From:
Sent: 22 September 2023 15:58
To: DCAdmin
Subject: Emley planning objections

Comments in relation to the following applications by Newett Homes;

2023/92255 Land at Green Acres Close, Emley, Variation of Conditions 1 (Plans) , 2 (Crime Prevention) and 15 (Permitted Development) of Previous reserved matters approval 2021/93286 pursuant to outline permission 2020/91215

And
2023/92327 Land at Green Acres Close – modified plans for 6 Dwellings plus parking and landscaping and modified plans for ball stop netting.

Drawing Title	Ball Strike Net		
Site	Wentworth Drive, Emley		
Scale	1:100/1:200 @A2	Date	27/06/23
Drawn	MC		
Drawing No.	2155.110	Rev.	-
Thorpe Arch Grange Walton Road Thorp Arch LS23 7BA 01937 543599 www.newethomes.co.uk

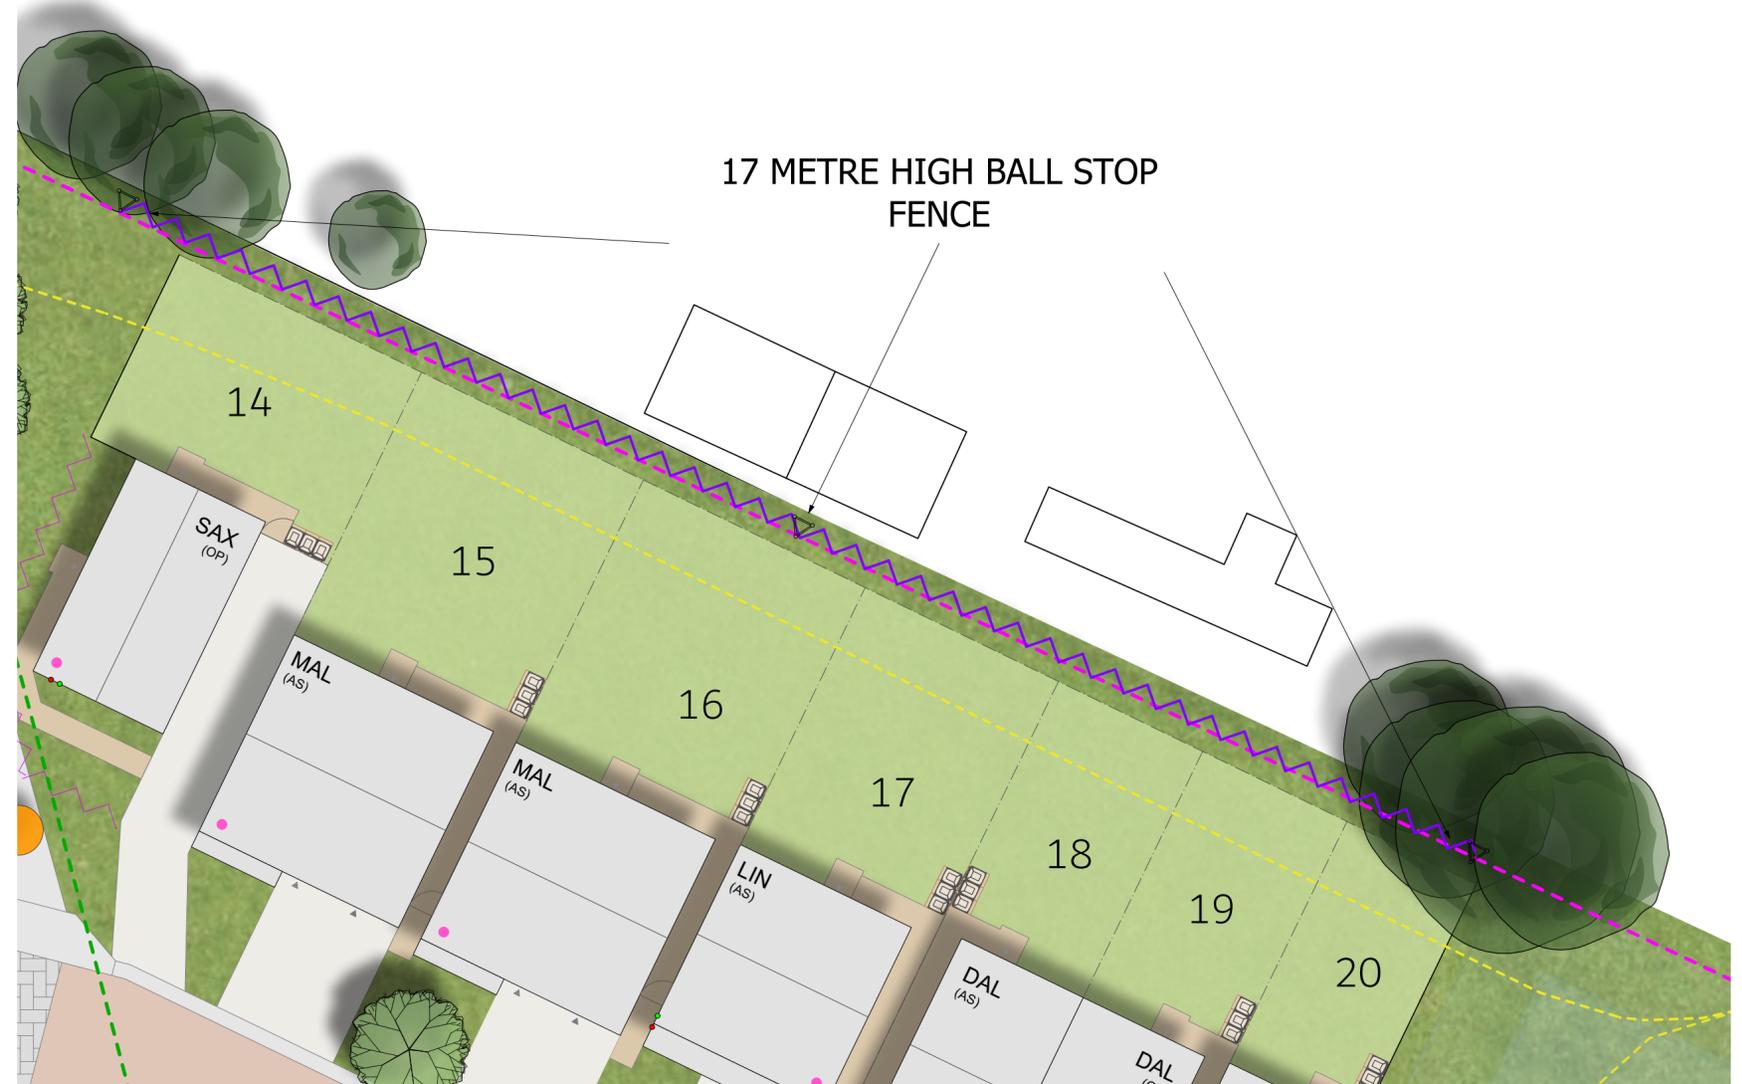
8 – The submitted ‘Cricket Pitch Section’ plan and the ‘Ball Strike Net Plan’ both dated 27/06/23 prepared by Newett Homes is not sufficient. There is no information or evidence to show that the stanchions/supports and netting design nor the new position of the net, nor the height of the net is adequate. The cricket field and the development land are exposed to high winds and adverse weather and this needs to be factored into any design. The balls strike netting needs to be robust enough to withstand the extremes of weather experienced in Emley, and to prevent rattling and whistling noises disturbing residents in the vicinity.

10 - The proposed netting and its height is not what was approved in the Planning Application 2021/93286. The Labosport LSUK.21-0698 dated 19/11/2021 gave a height of 18 metres but Newett are now using 17 meters. A new Labosport/Newett Boundary Risk A new assessment is required to look at the heights again particularly due to the proposed nets being moved and the claimed PROW now being incorporated into the new design. As already stated this should be a physical survey by Labosport not a desk top survey, they need to visit the site to appreciate the position and the situation.

11 - The proposed netting is not only lower than it should be but it does not extend to the perimeters originally proposed. It is shown as not extending the full length of the cricket field wall, ie where the proposed attenuation tanks are to be grassed over and the development children play this area is not covered by the safety of the nets. Are children not as important as the houses. This is of course in addition to the fact that there will need be access for a "cherry picker" machine space for repair / maintenance of the ball stop netting - which would need a clear 3.00 m drive way, and this is not reflected in the most recent proposals to Kirklees.
